TfNSW Reference: SYD22/00124/03

Re: ADDITIONAL INFORMATION
OAKDALE EAST INDUSTRIAL ESTATE (SSD-37486043)
2-10 WALLGROVE ROAD, HORSLEY PARK

Attachment A – TfNSW Comment

Figure 4: Intersection Upgrade Works – Old Wallgrove Road / Millner Avenue (site entrance)

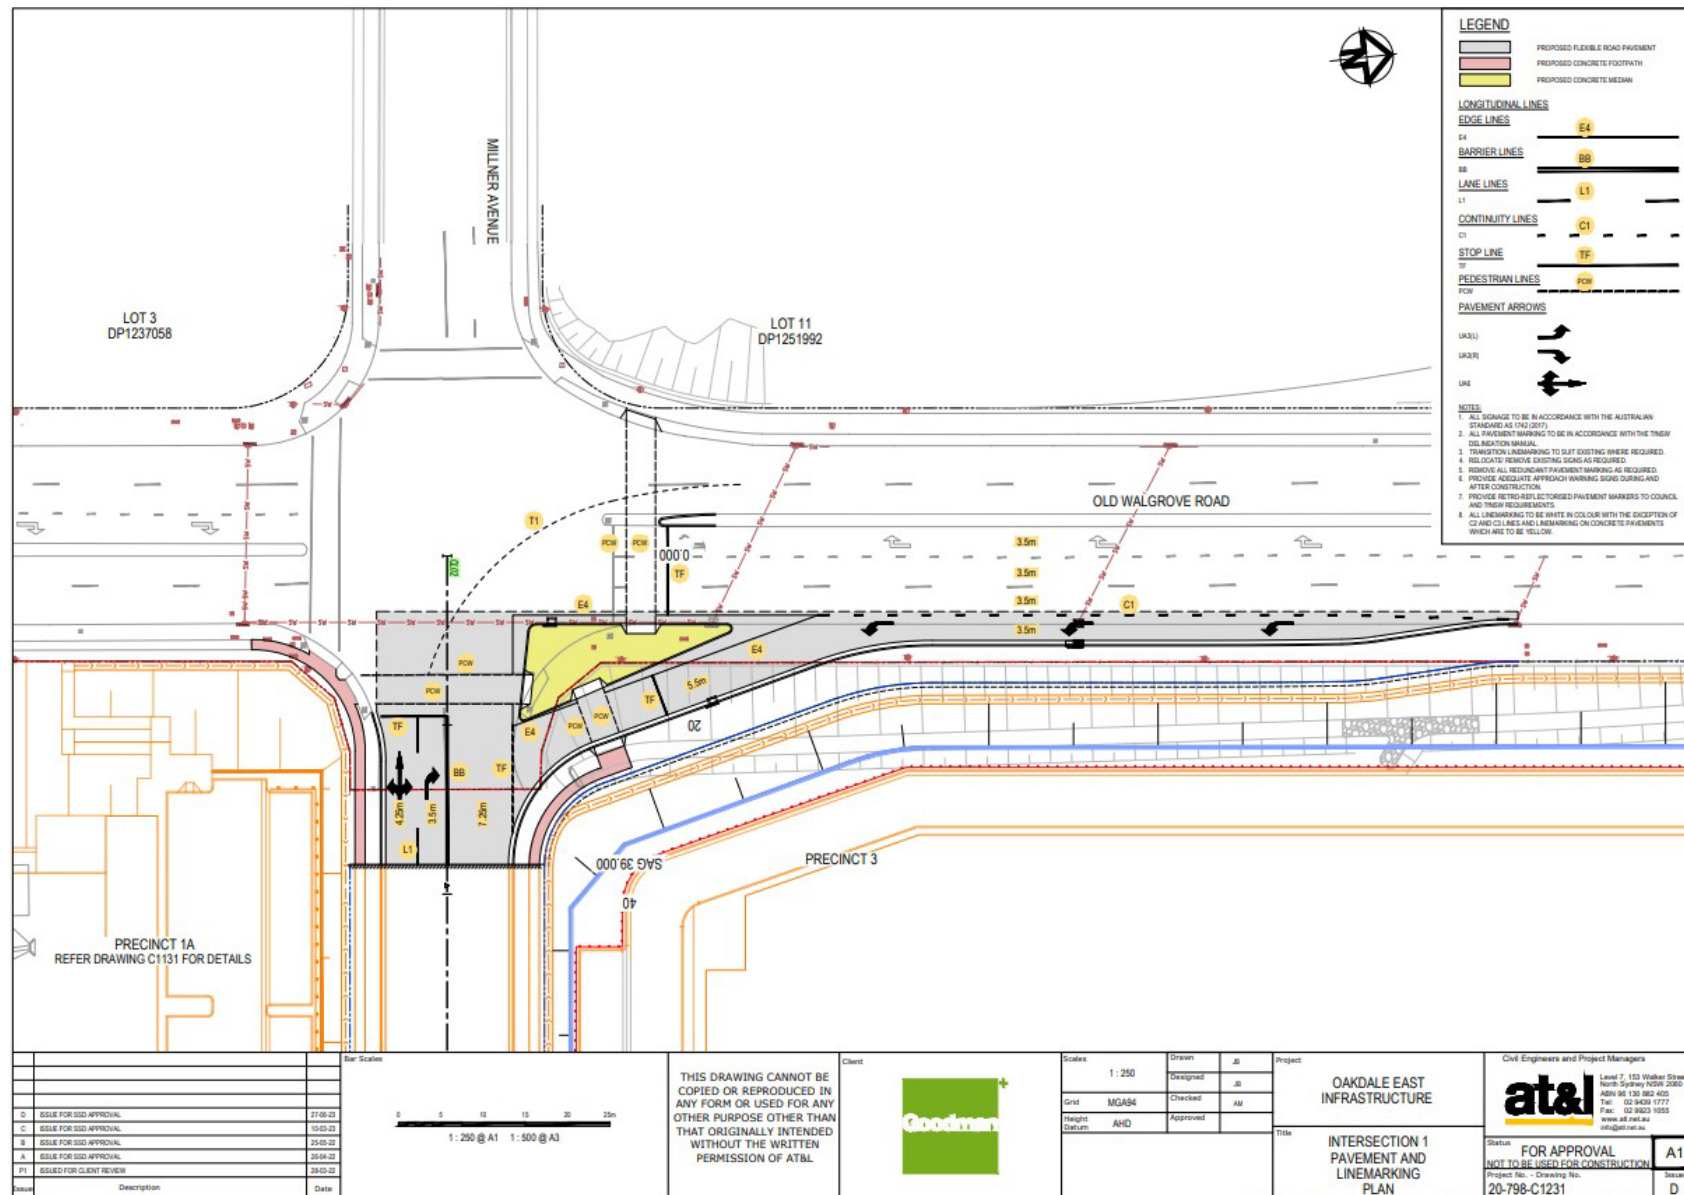
The proposed truck access to/from the site on Estate Road 1 is located close to the signalised intersection of Old Wallgrove Road / Millner Avenue. The access should be incorporated into the Sidra modelling demonstrating it does not have adverse impact to the operation of signalised intersection. The proposed distribution diagram should be provided with queue assessment at this location. The proponent should investigate relocating the access further to the intersection.
